# **KITITAS COUNTY**

### **MEMORANDUM**

TO: All Staff  
FROM: Justin Turnbull, County Surveyor   
DATE: December 23, 2019  
SUBJECT: Second County Survey Review of BLA BL-19-00016 Lytle  
(The map shows Kevin Merrell as the applicant, Lytle is not shown anywhere)

DWN BY	DATE	JOB NO.
G.W.	12/2019	100811
CHKD BY	SCALE	SHEET
M.K.K./D.L.P.	1" = 100'	1 OF 2

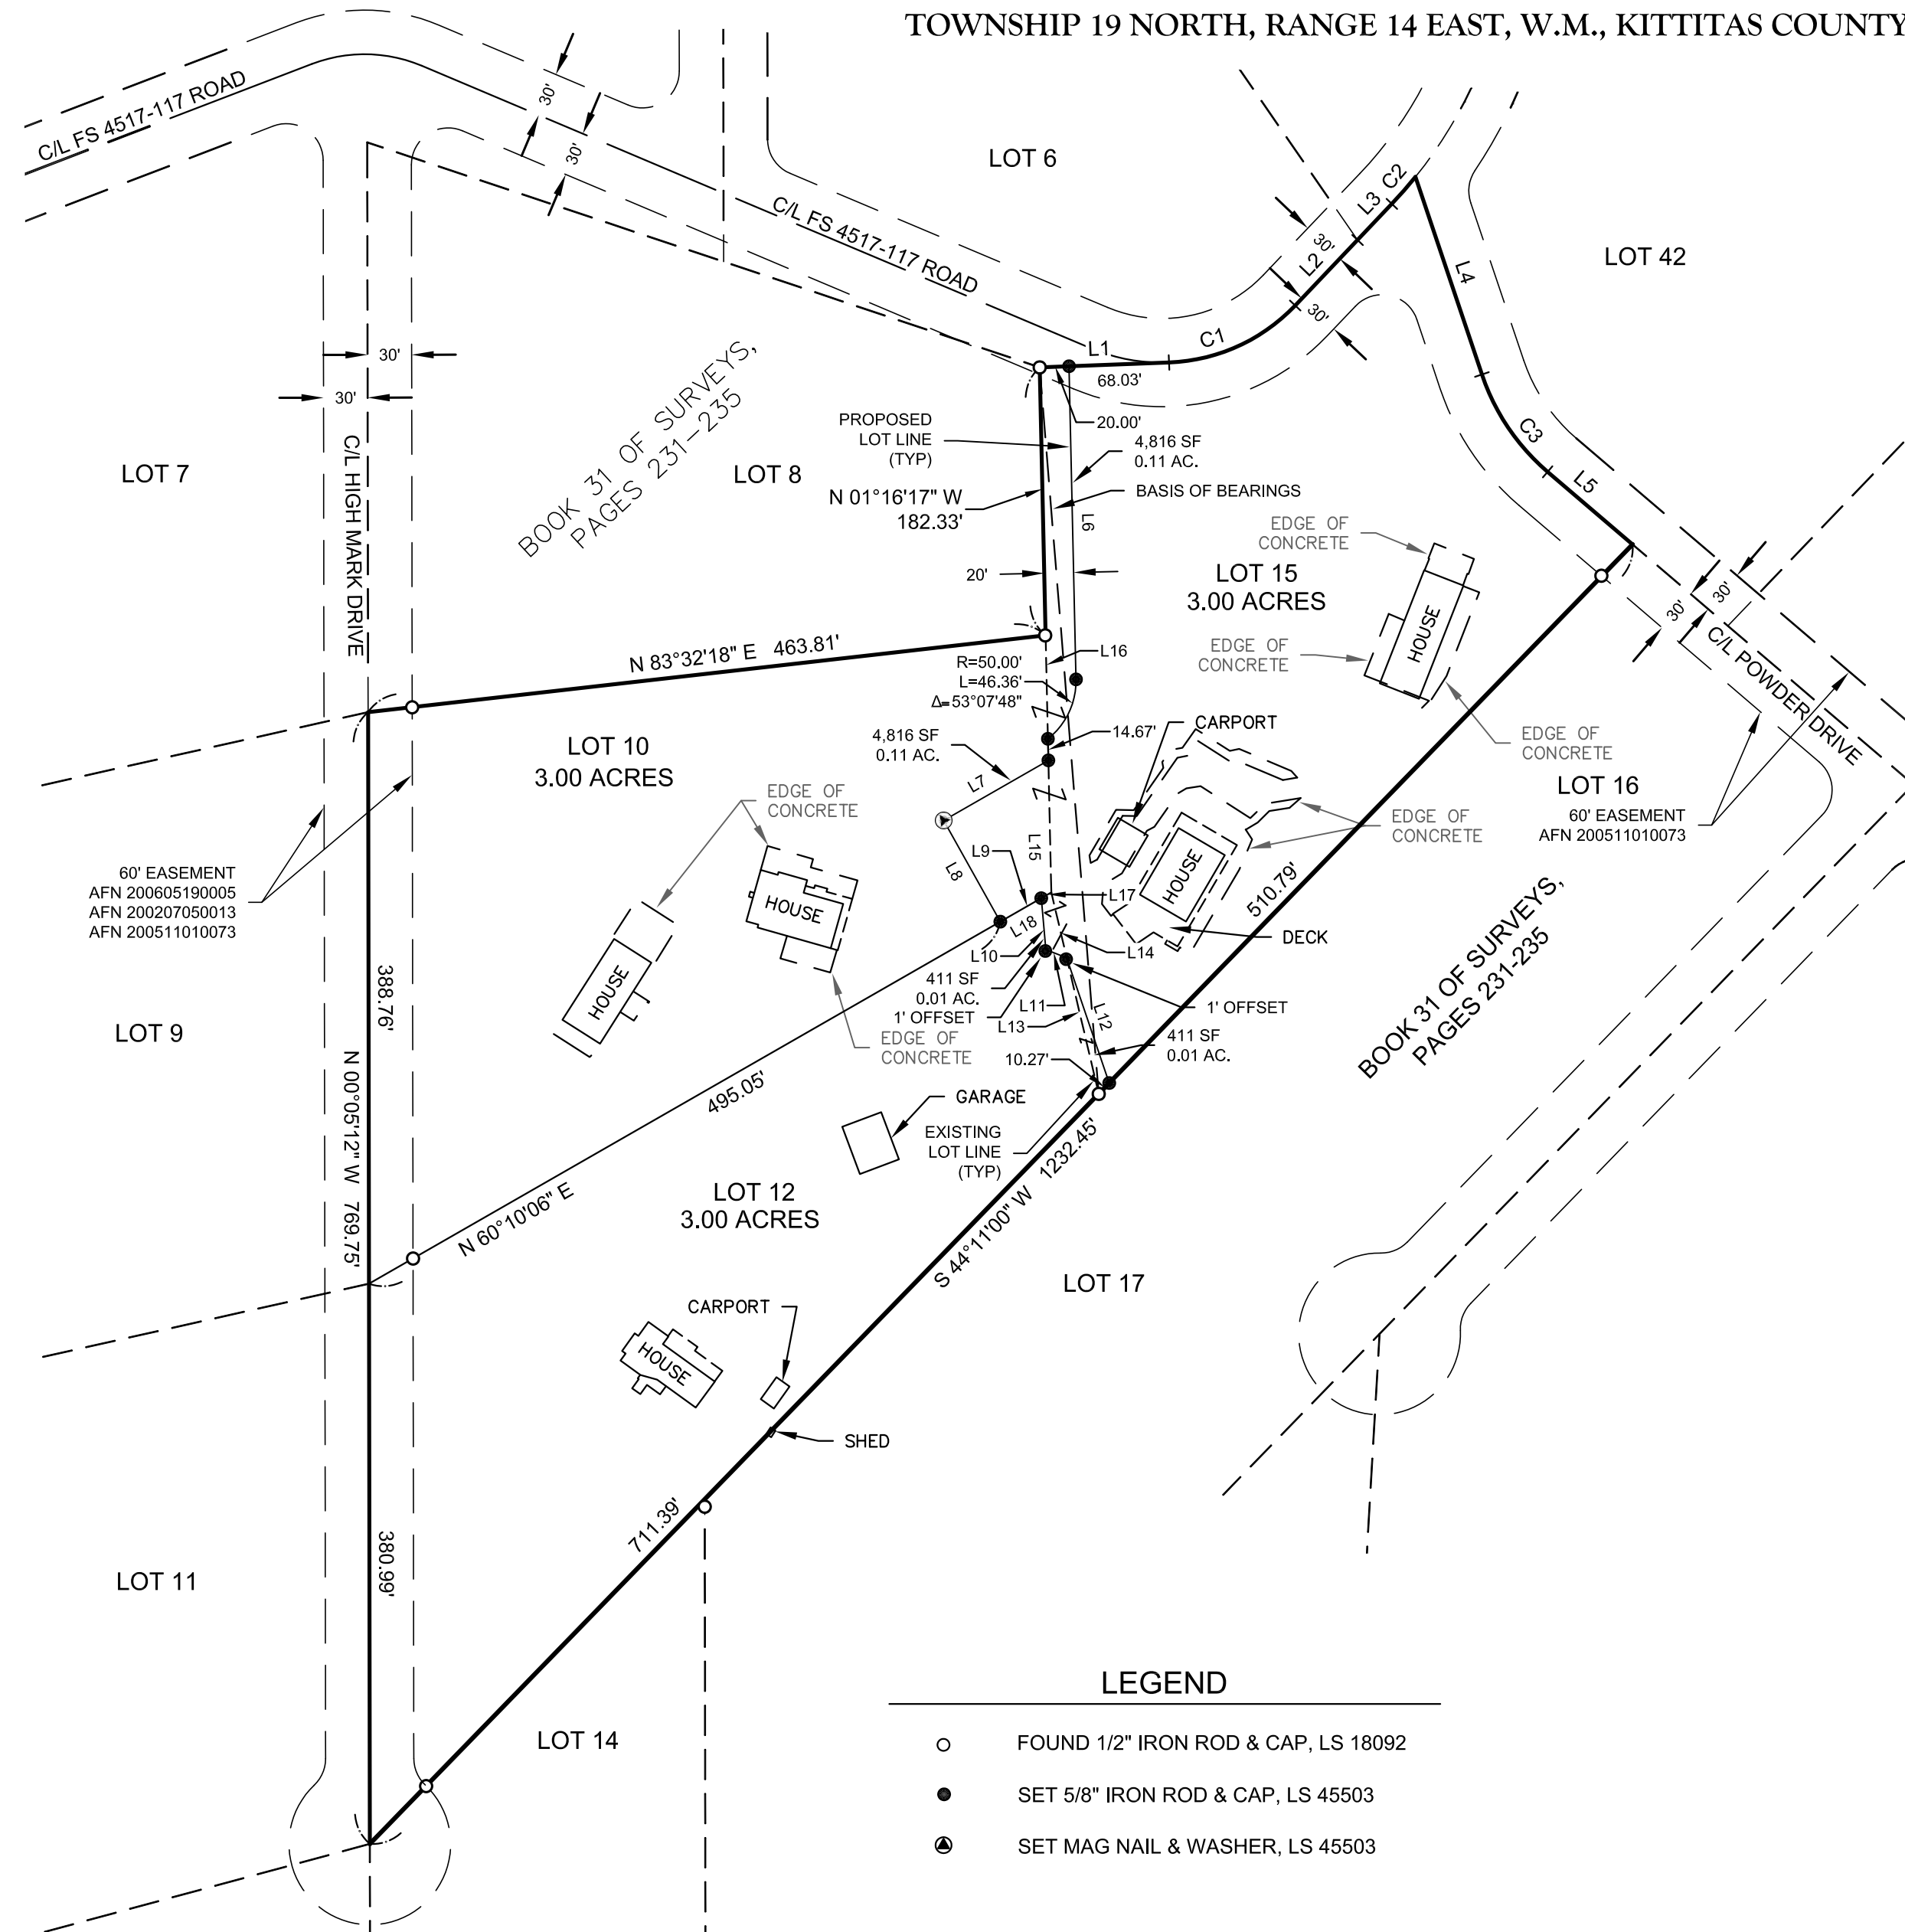
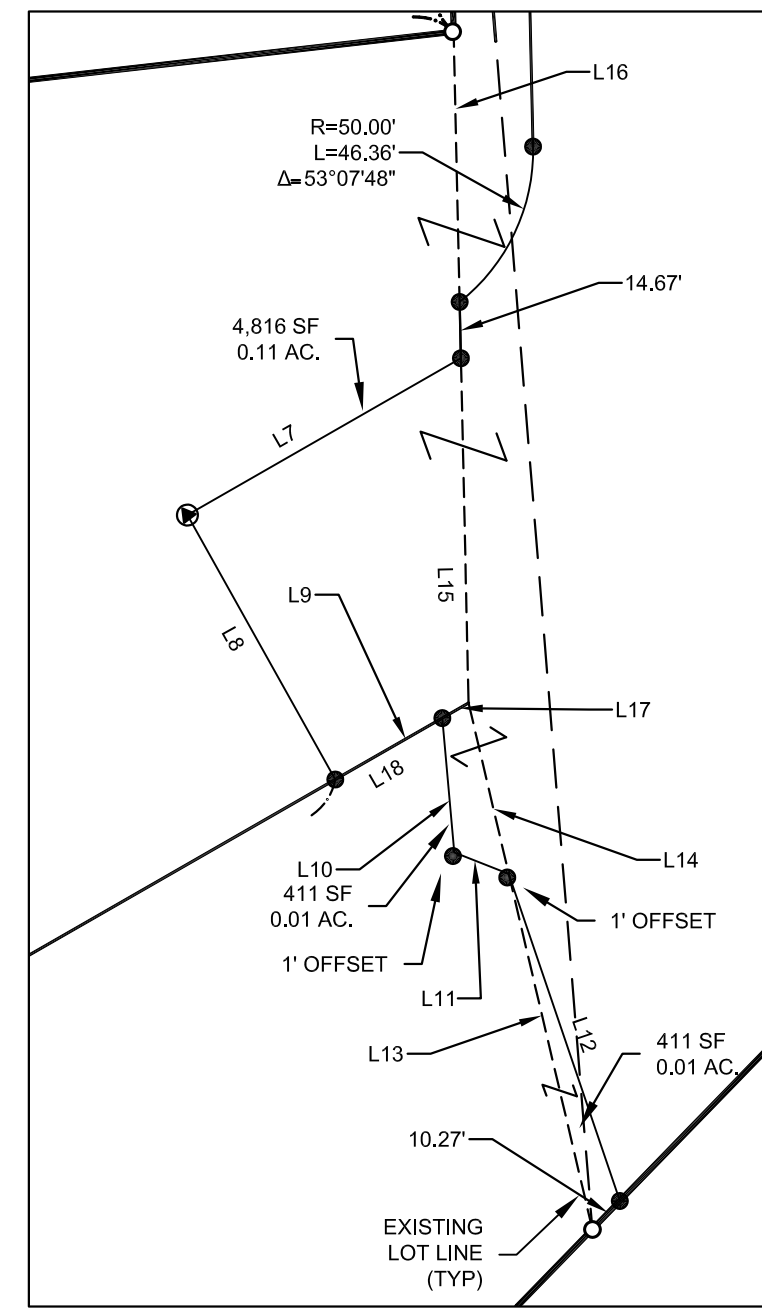
1. The Basis of Bearing references a line that does not include a bearing, nor does it refer to a document of record identifying this line.
